Application number: 2026/91251	
What is the application for?:	Outline application for erection of residential development of up to 9 dwellings
Address of the site or building:	land off, Meltham Road, Marsden, Huddersfield, HD7 6JZ
Postcode:	LS1 2JS

Type of comment: An objection	
Do you wish your comments to be published on the website anonymously?	No

Image 1.9 Proposed B6107 Meltham Road Site Access

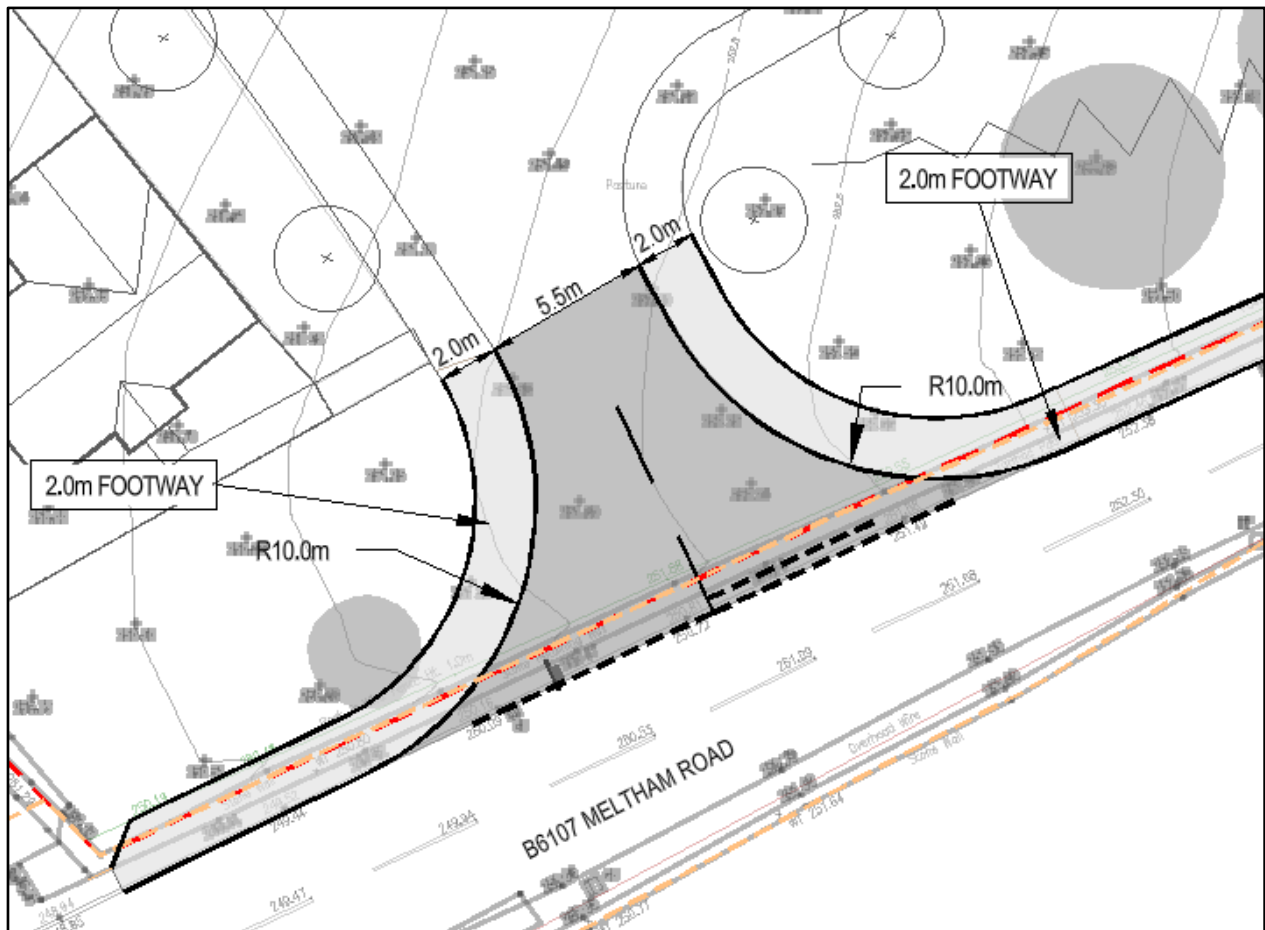
Poor visibility over the same break of slope, compounded by the slight left bend when approaching from the Meltham direction. is also the reason that a new vehicular access should not be permitted here. The tracking illustrated demonstrates that a large vehicle turning left out of the development would completely block the road in the blind spot, introducing a significant new hazard completely ignored in the Transport Plan reasoning.
